Subject: EP/22/19/PL - Further information request

Existing Proposed Plans elevations dwg.no. 882601 Rev A dated Dec 18

block/site plan (A1 1:250 A3 1:500)

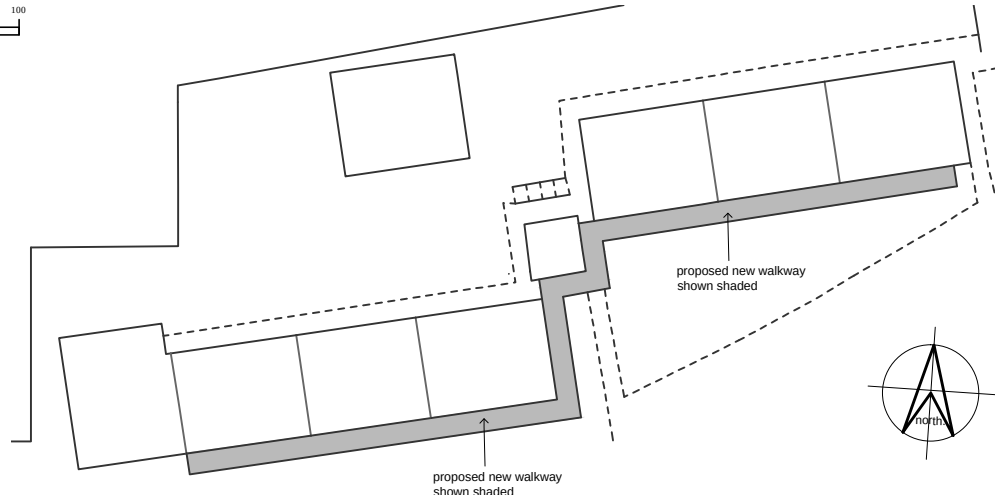
Block/Site Plan shows walkway on front elevation of no. 54/60 only

Please amend plan to remove this.

proposed (East) elevation (A1 1:100 A3 1:200)

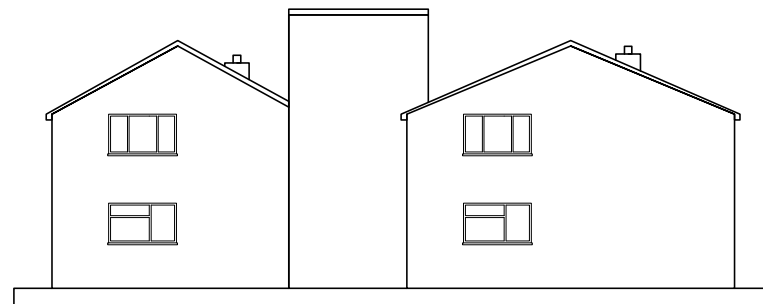
Proposed East elevation shows walkway on East Elevation of 54/60
